Silverado Ranch, Filing 2 Transportation Memorandum (LSC #S224530)

JANUARY 30, 2024

RE: Silverado Ranch, Filing 2
Transportation Memorandum
El Paso County, CO
LSC #S224530

Figure 2
Filing No. 2 Site Plan
Silverado Ranch Filing No. 2 (LSC#S224530)

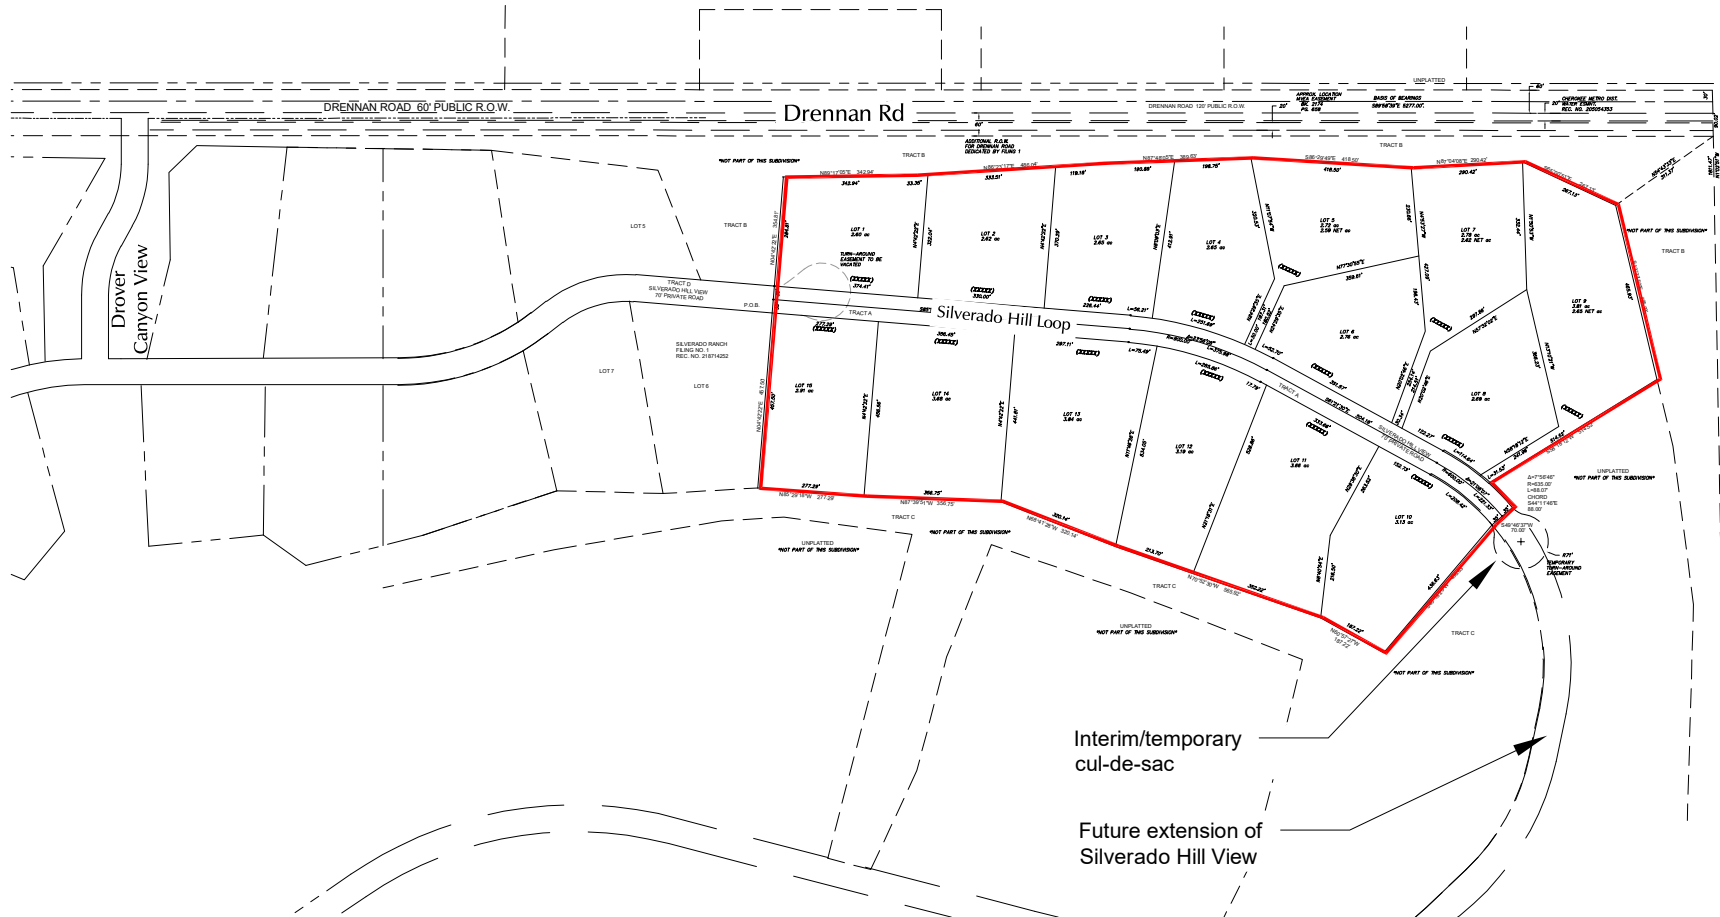
Silverado Hill Loop per F1 plat.
Please update throughout report
